City of Portland, Maine - Building or Use Permit Application

Proposed Project Description: Construct a 140' x 60' Steel Building for Multi Tenants/Commercial	Signature: <i>[Handwritten Signature]</i>	Signature: <i>[Handwritten Signature]</i>
PEDESTRIAN ACTIVITIES DISTRICT (P.A.D.)		
Action: <input type="checkbox"/> Approved <input type="checkbox"/> Approved w/Conditions <input type="checkbox"/> Denied		
Signature:		Date:

Re: Morrill St. Associates 57 Bell St. 150b001

PROJECT TITLE: M.R. BREWER FINE WOODWORKING - SITE DEVELOPMENT

CROSS SECTION AT FRAME LINES "2" THRU "5"

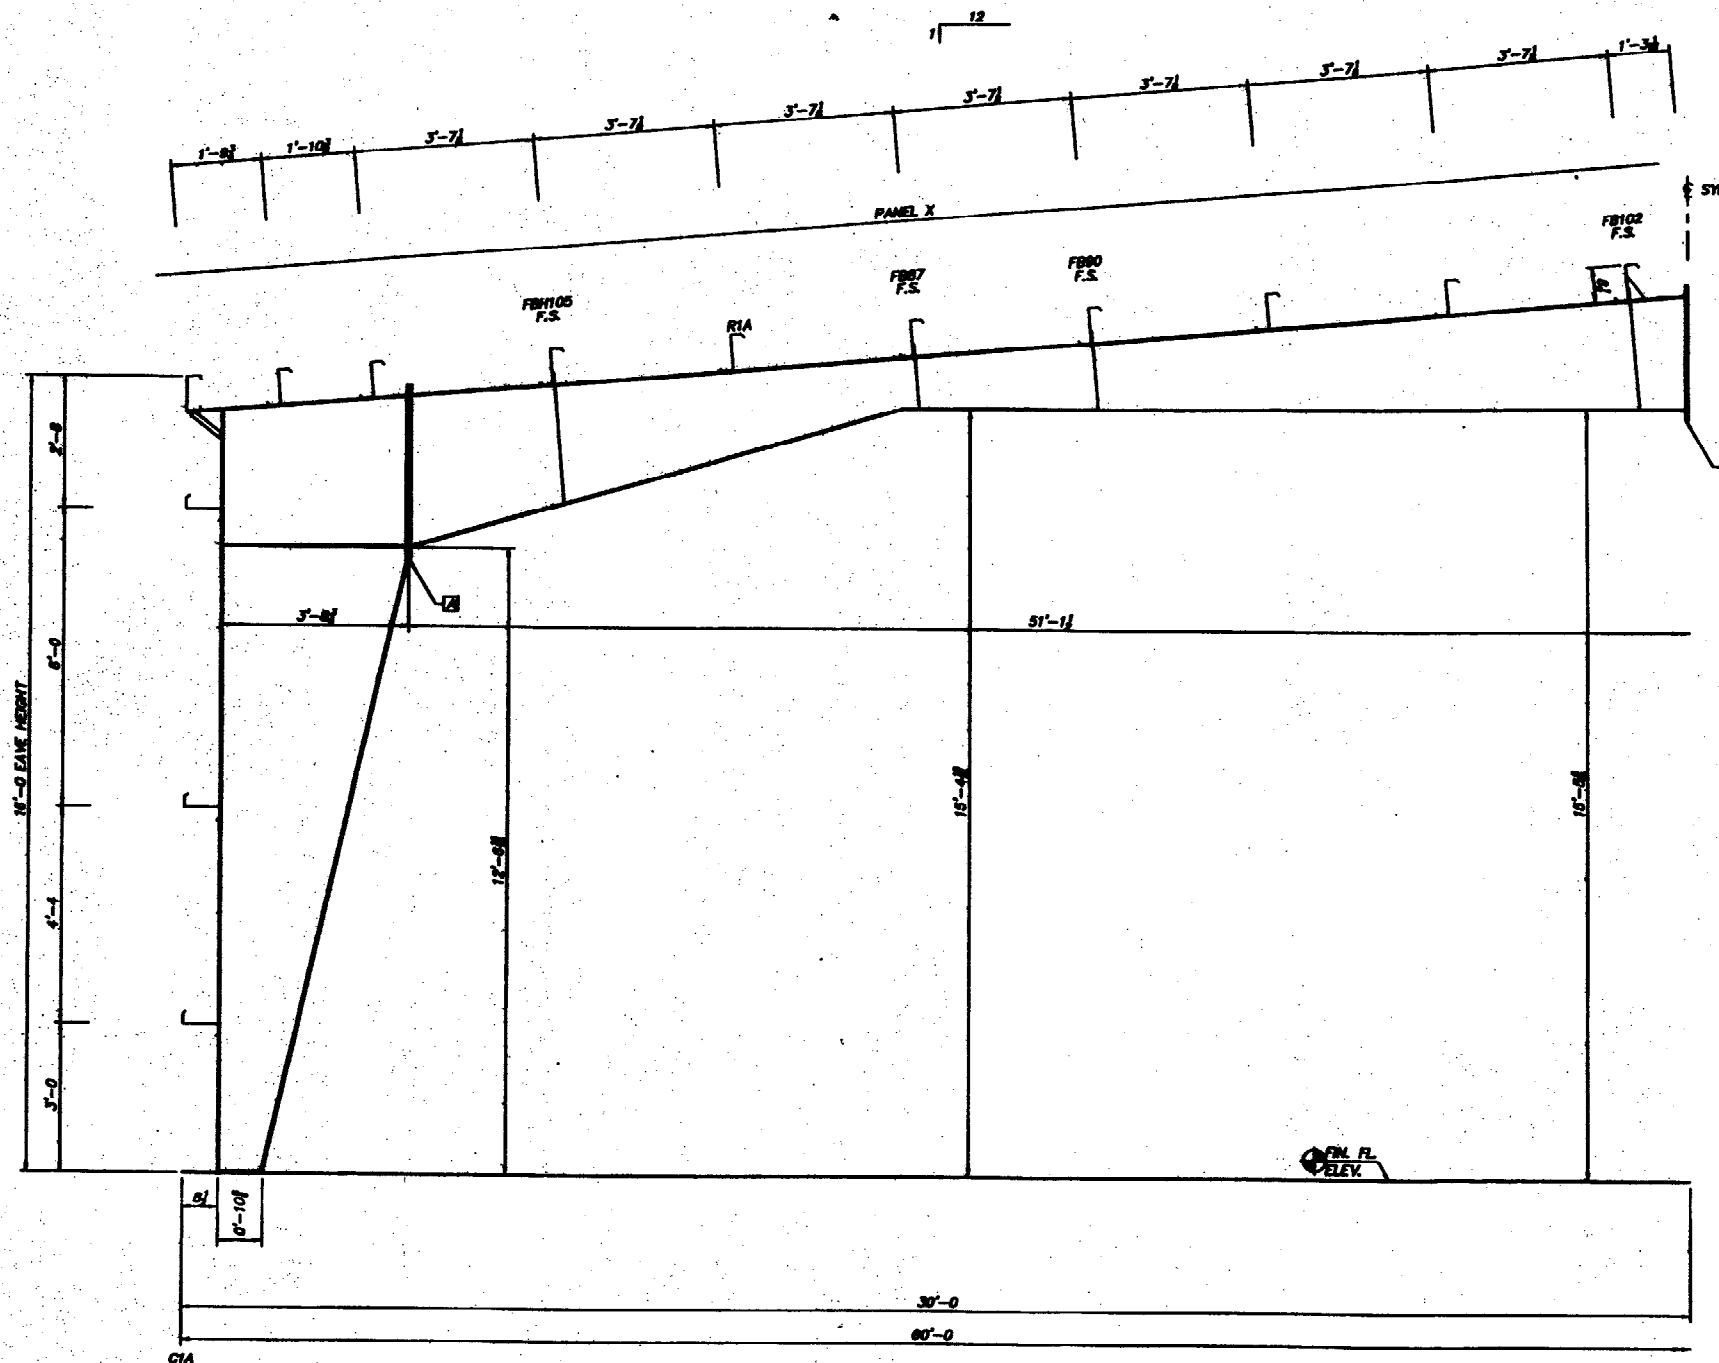
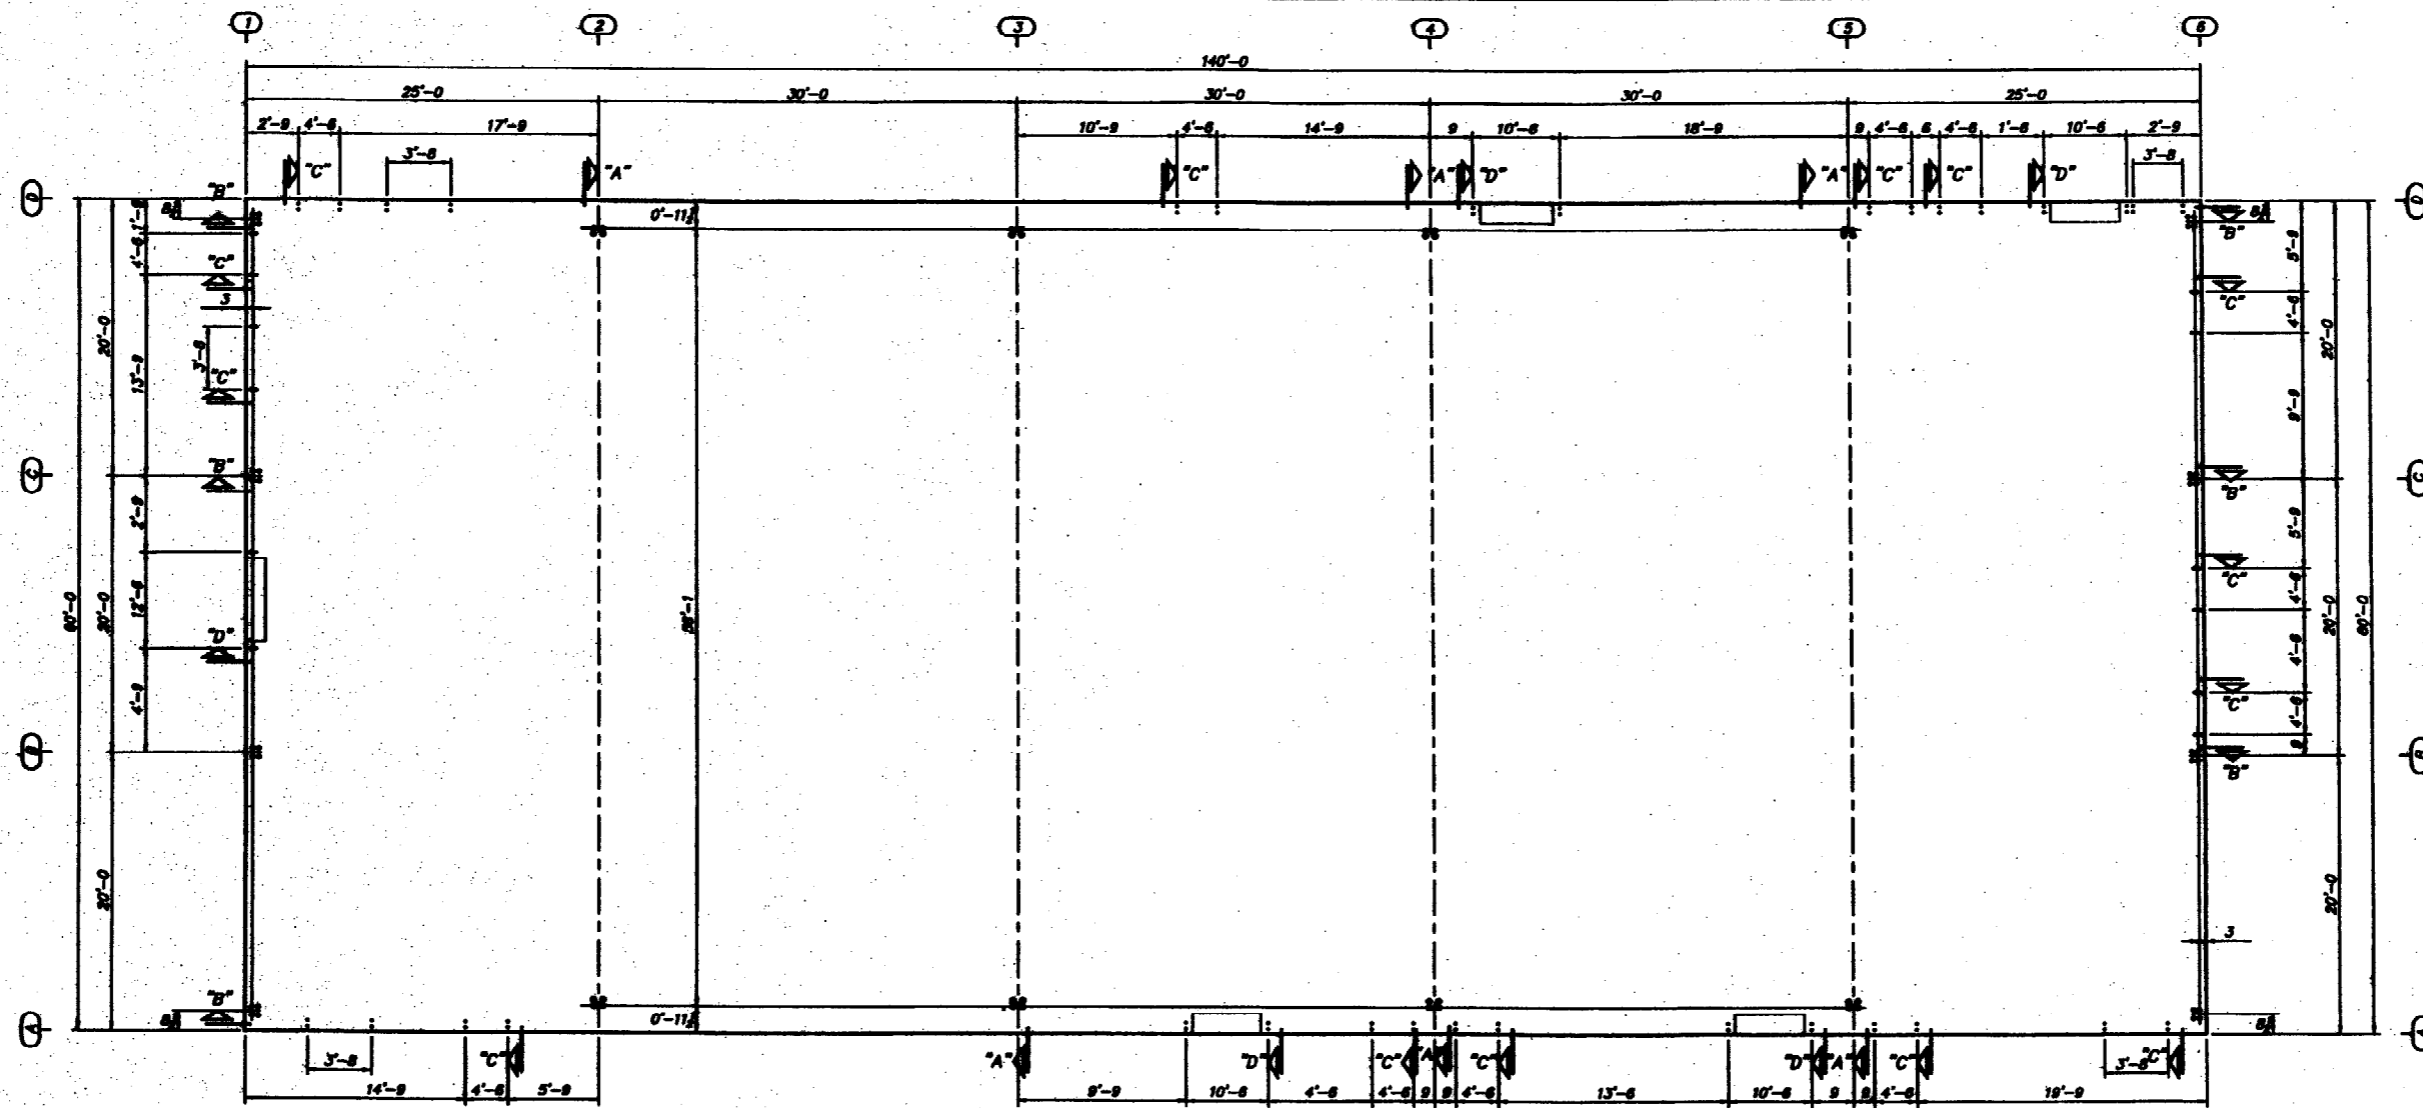
An additional 8.5"Z.088 wall girt is required at 7'4" elevation in bay #2 of sidewall "A". An additional 8.5"Z.088 wall girt is required at 7'4" elevation in bays #2 and 4 of sidewall "C". An additional 8.5"Z.088 wall girt is required at 13'4" elevation in bay #1 of sidewall "C". An additional 1 1/2" x 1 1/2" x 1/8" rafter flange brace angle is required at the 6th purlin from each eave on one side of the frame rafters along column lines #2-5.
